June 3, 2016

Bayside Bowl

Permit Review Comments Responses

7 WEST STAIR ROOF EDGE FLASHING DETAIL (LOWER PORTION SHOWN UPPER PORTION SIMILAR)
3" = 1'-0"

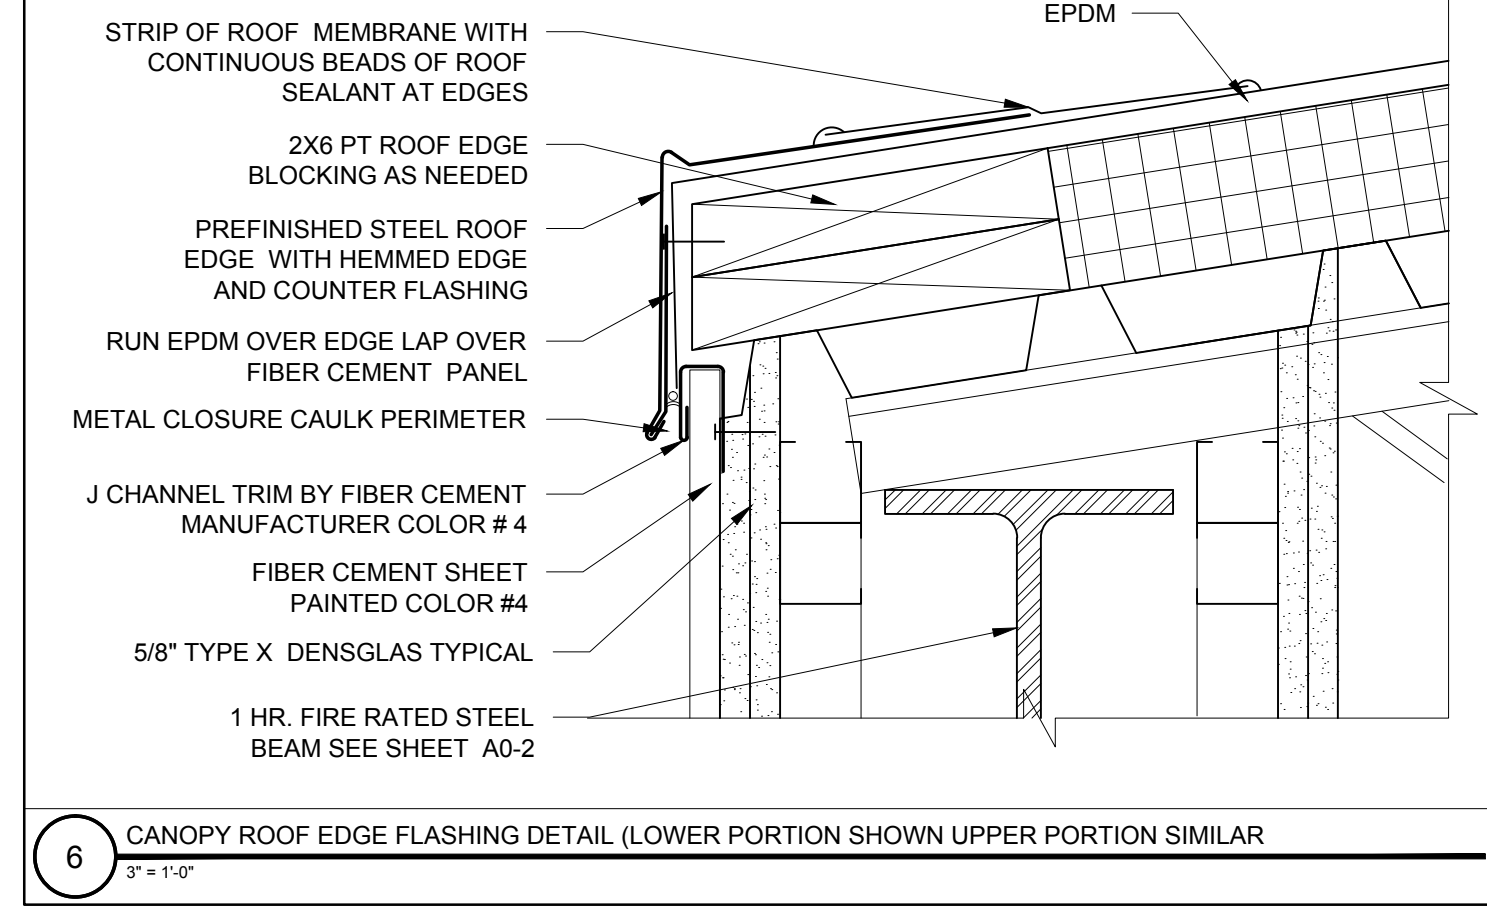
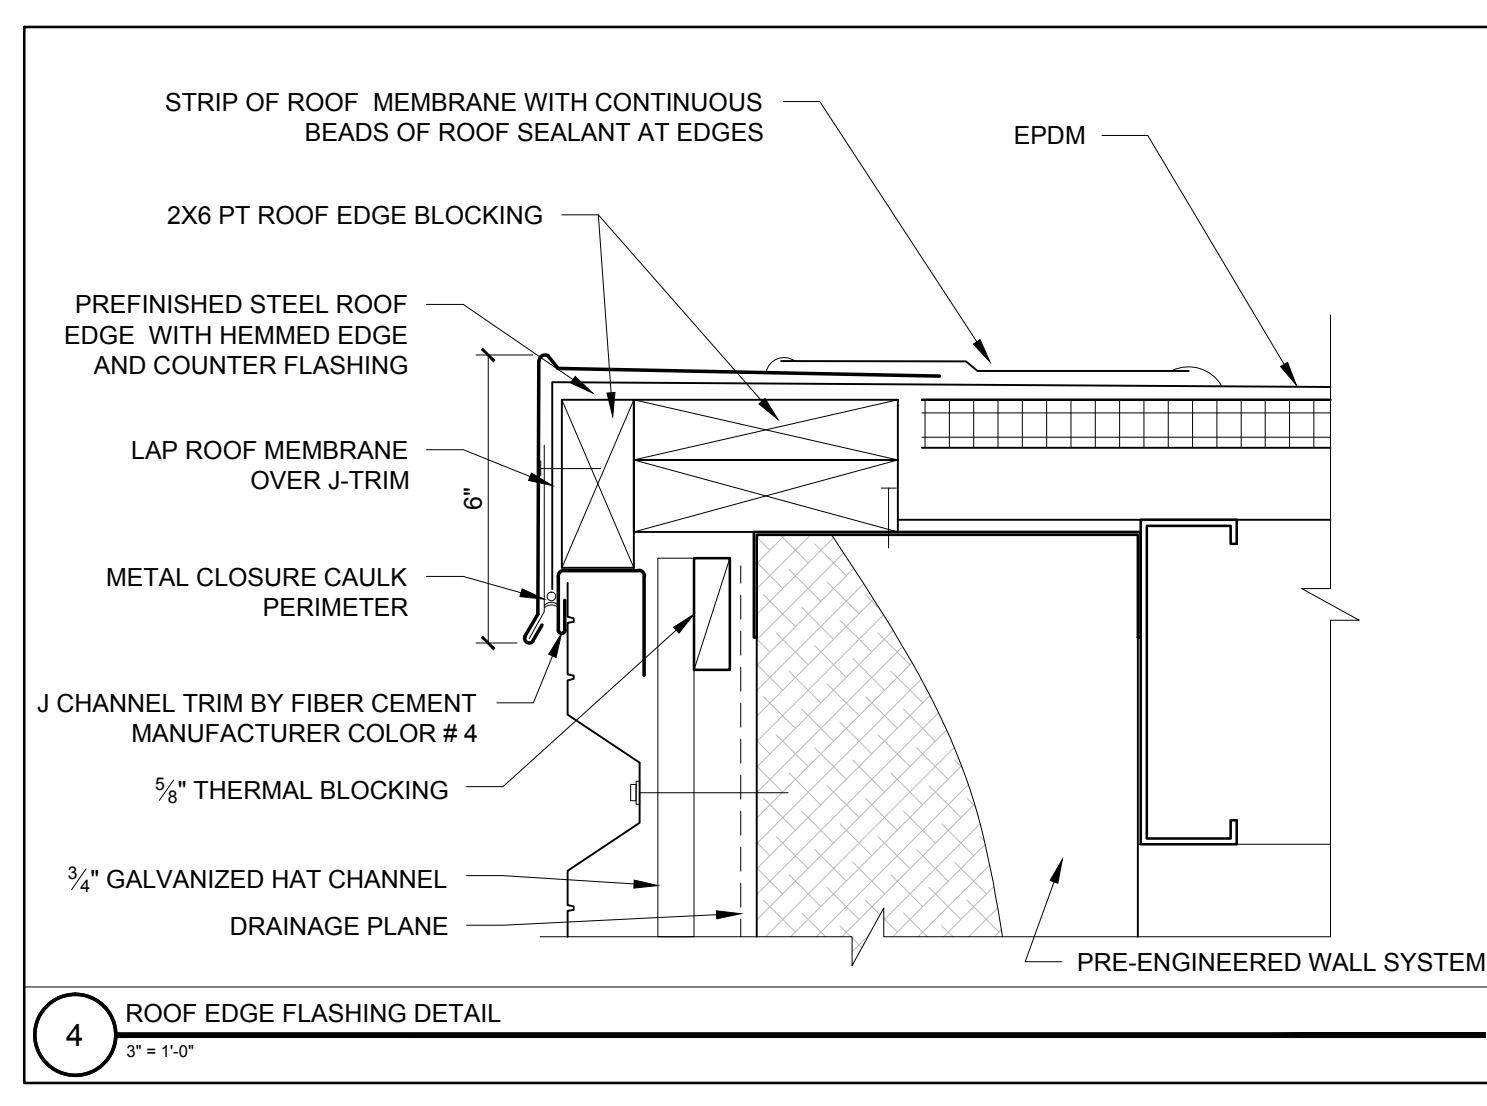
- 5.) A5-8, please see the revised sheets A5-1, A5-5, A5-6, A5-7 and A5-8 showing Fire treated roof blocking in lieu of PT blocking.
- 6.) A5-4, the detail was incorrectly tagged it is corrected as Detail 4/A5-2 on the attached sheet.
